COMMUNITY & NEIGHBOURHOOD OBJECTION SUBMISSION

Application Ref: SSD-81426710 (Amended Mixed-Use Development, 138 Maroubra Road)

Submitted By: Combined Adjoining Neighbors & Surrounding Community Members

DRAWN BY	SCALE	SHEET SIZE	PRINT DATE
Author	1:100	A1	18/09/2025
DESCRIPTION			5:09:04 PM
GROUND FLOOR PLAN			
PROJECT No	DRAWING No	REVISION	
21_435	DA1.104	V

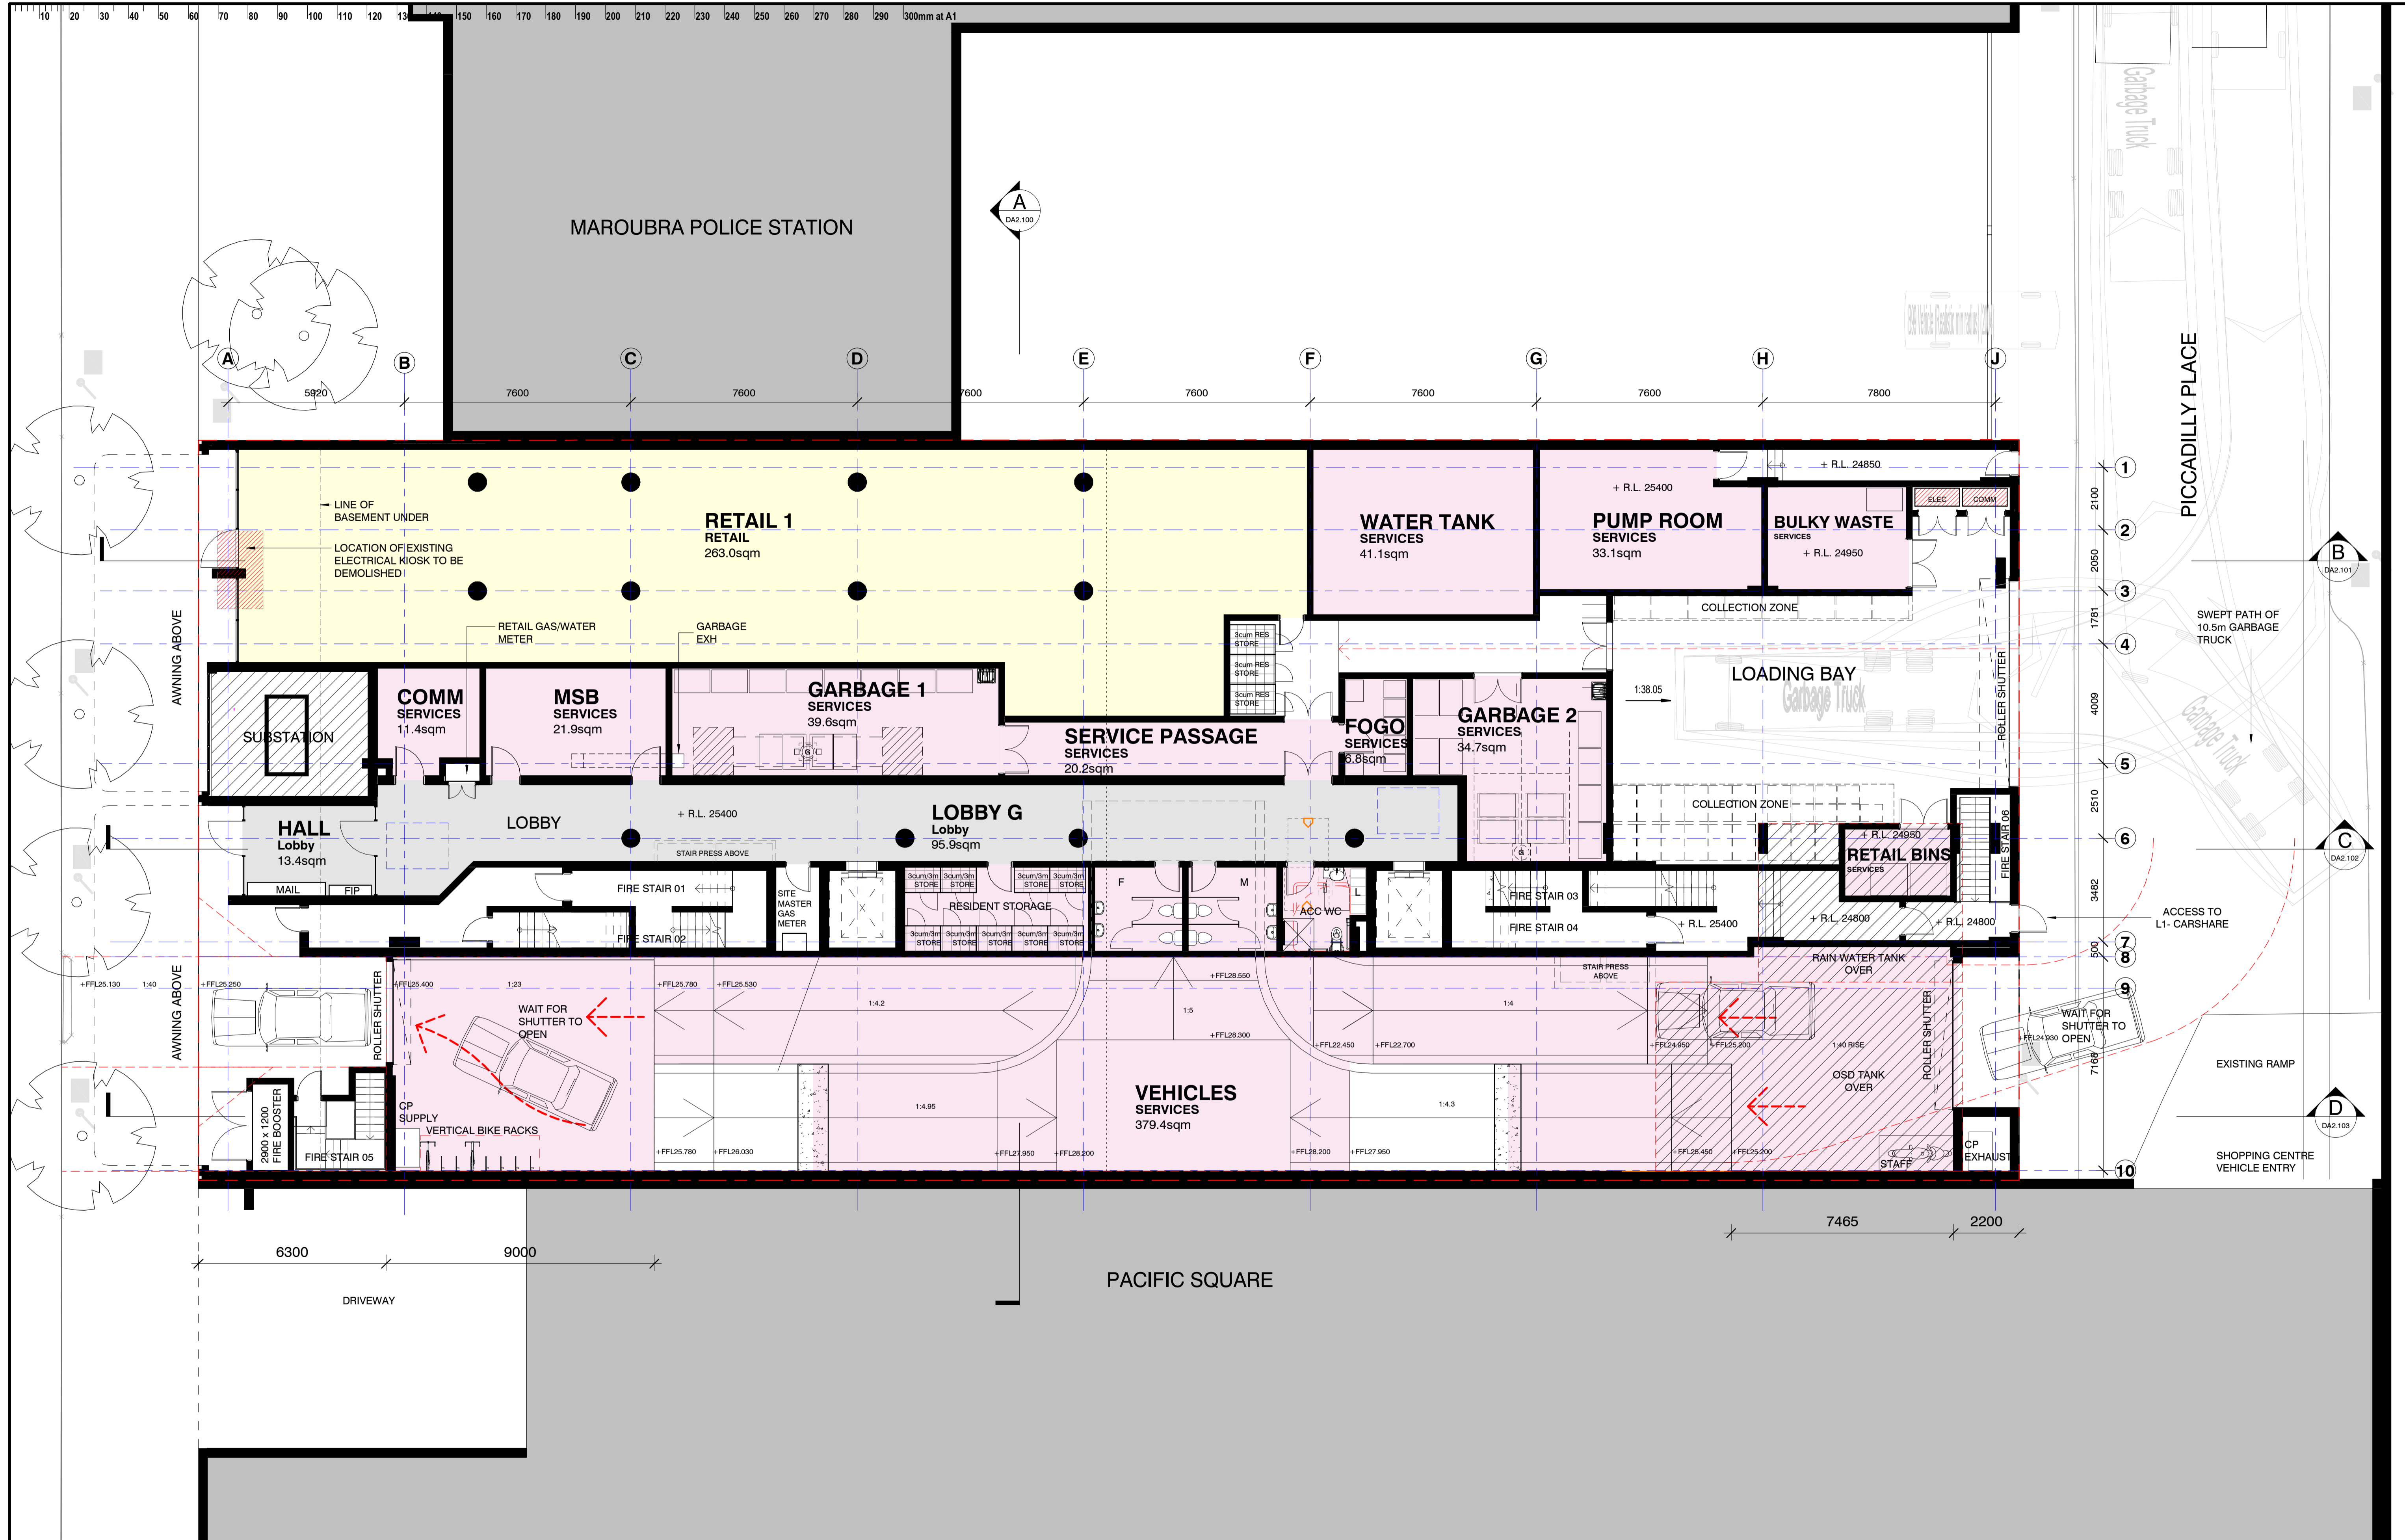
To bypass the severe access restrictions on Maroubra Road, the revised layout routes 100% of residential, visitor, service, and delivery vehicles directly through Piccadilly Place at the rear. This shifts the entire traffic burden into a narrow, constrained laneway network.

Piccadilly Place and the Bruce Bennetts Place roundabout are already severely bottlenecked by the heavy commercial loading operations of Pacific Square. Forcing an entire 10-storey development's traffic into this single entry point will trigger constant gridlock. For neighboring residents, this introduces severe acoustic pollution right beneath their windows. More critically, it creates an active collision hazard for the numerous community members—especially the high number of local senior citizens—who rely on this flat, level precinct for their daily walking, groceries, and medical access.

DRAWN BY	SCALE	SHEET SIZE	PRINT DATE
Author	1:100	A1	18/09/2025
DESCRIPTION			REVISION
WEST ELEVATION			5:15:36 PM
PROJECT No	DRAWING No	REVISION	
21_435	DA2.203	N

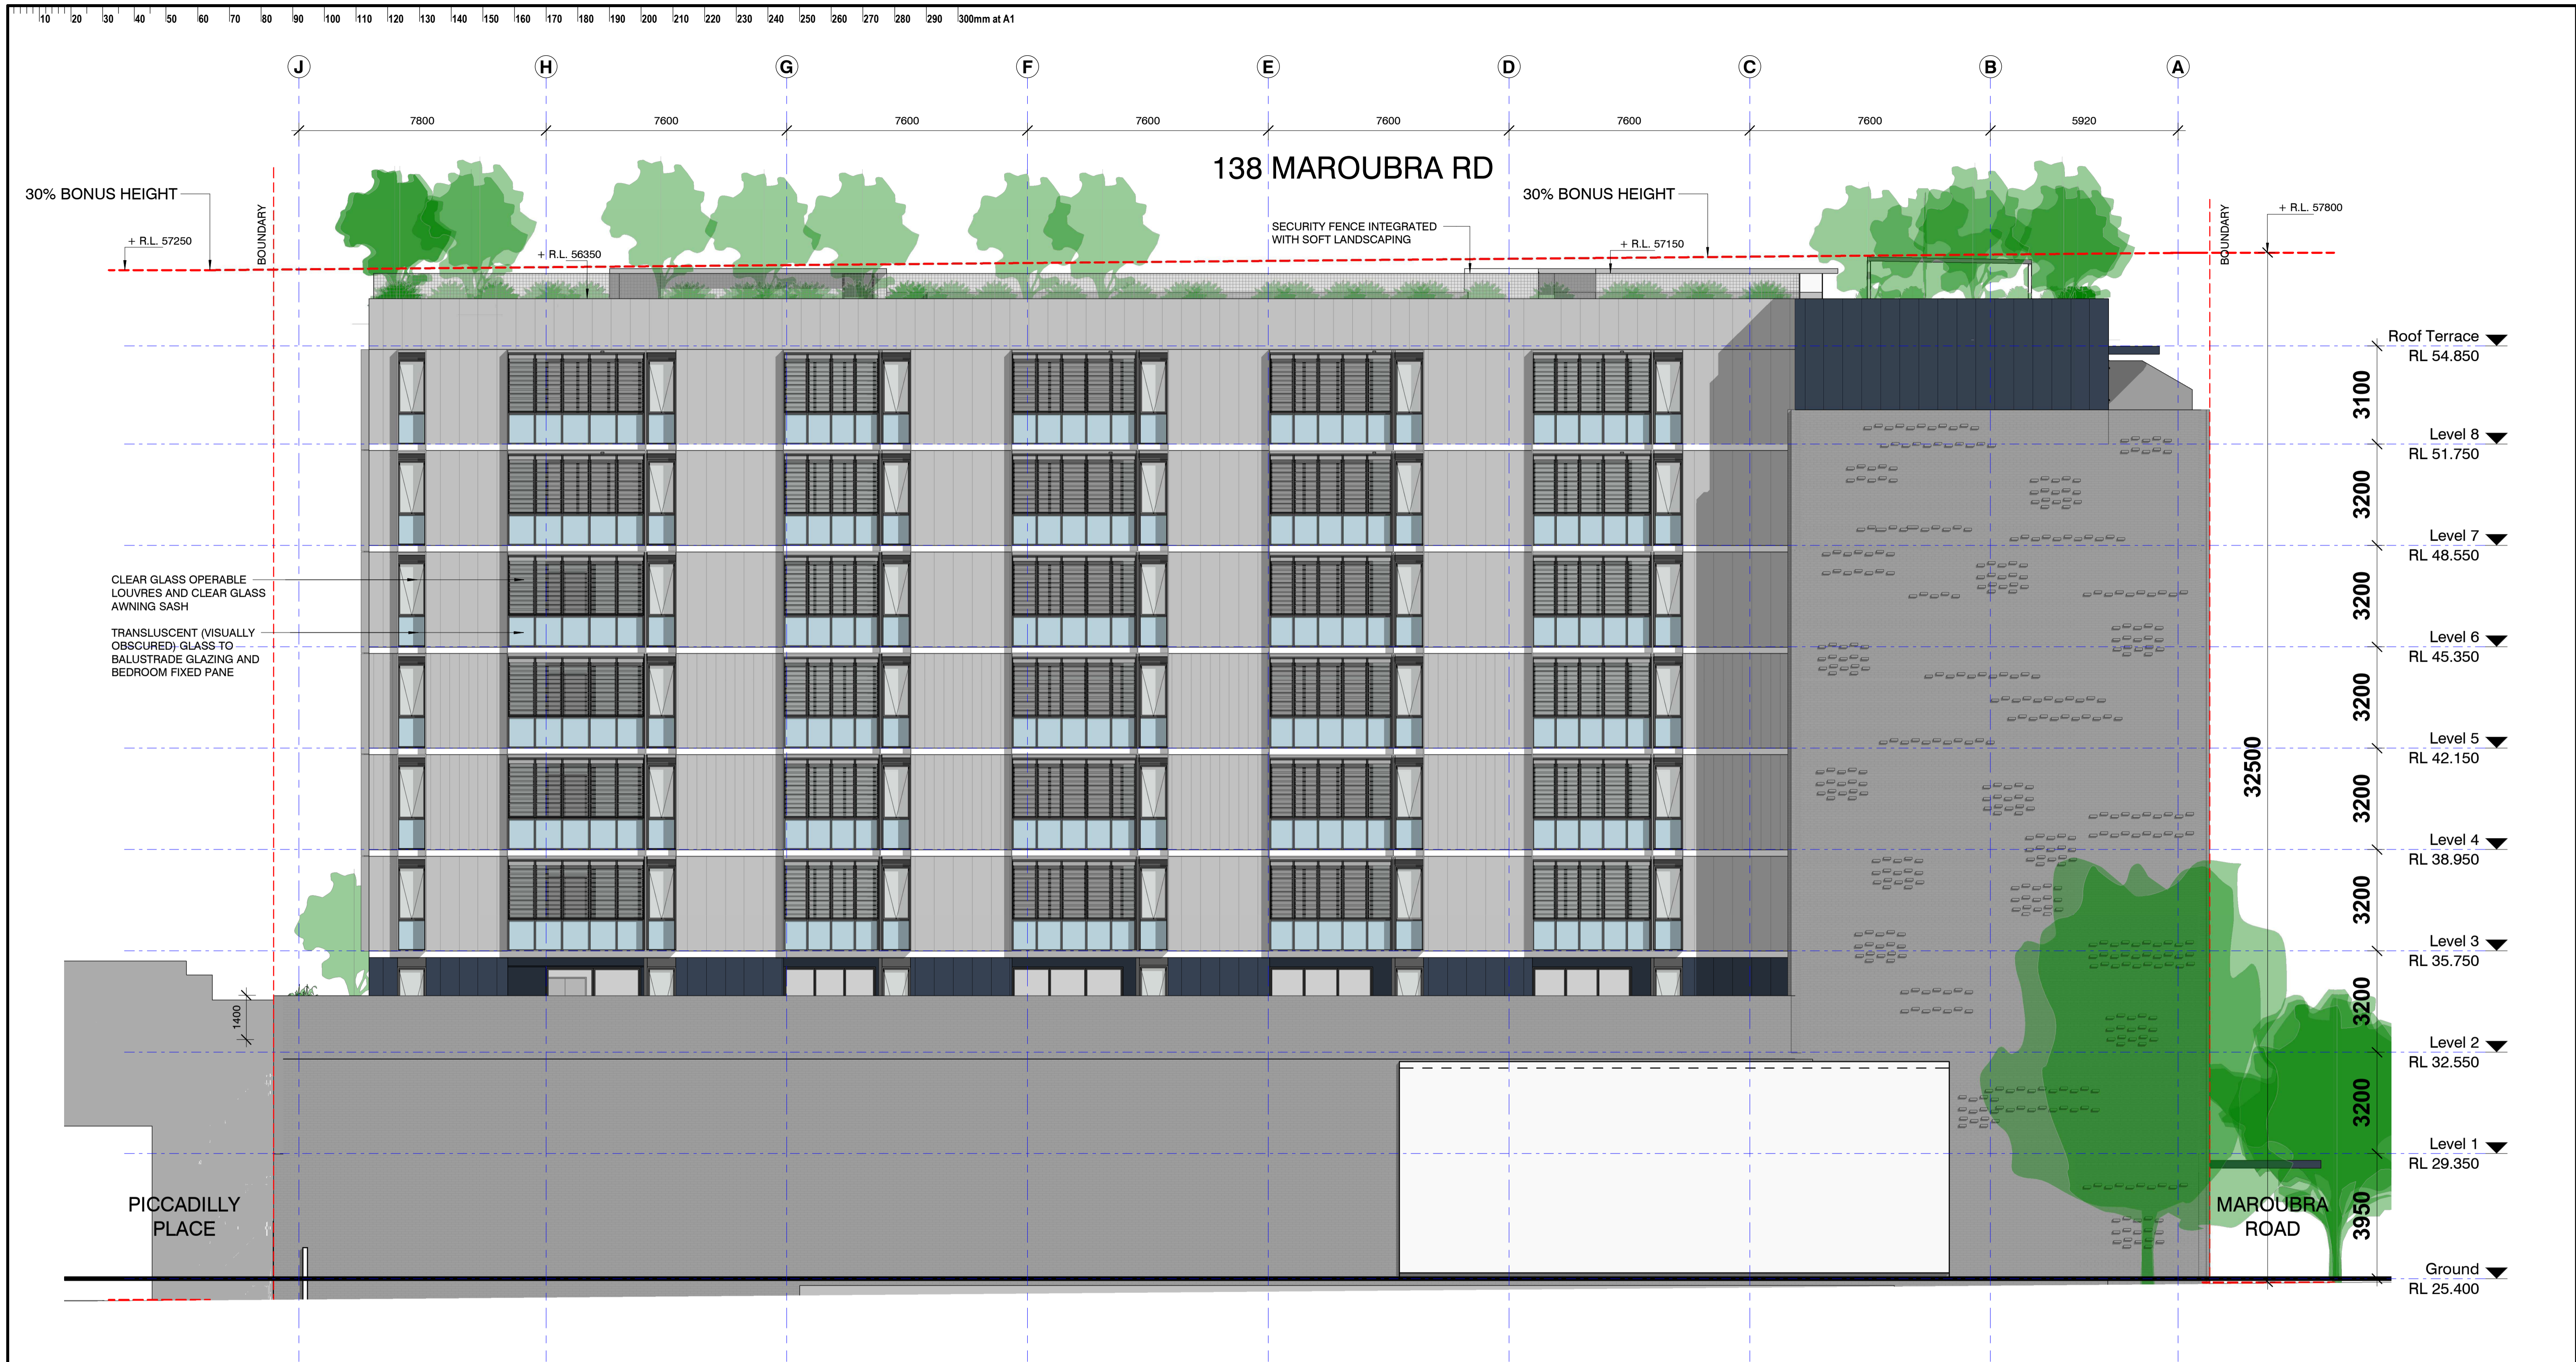
By pushing a continuous 32.5-meter vertical concrete face right up against the shared boundary line without any architectural stepping, the proposal inflicts permanent visual claustrophobia on adjacent homes. Neighbors will face a raw, monolithic 10-storey wall outside their windows, destroying their baseline sense of space, natural ventilation, and residential comfort.
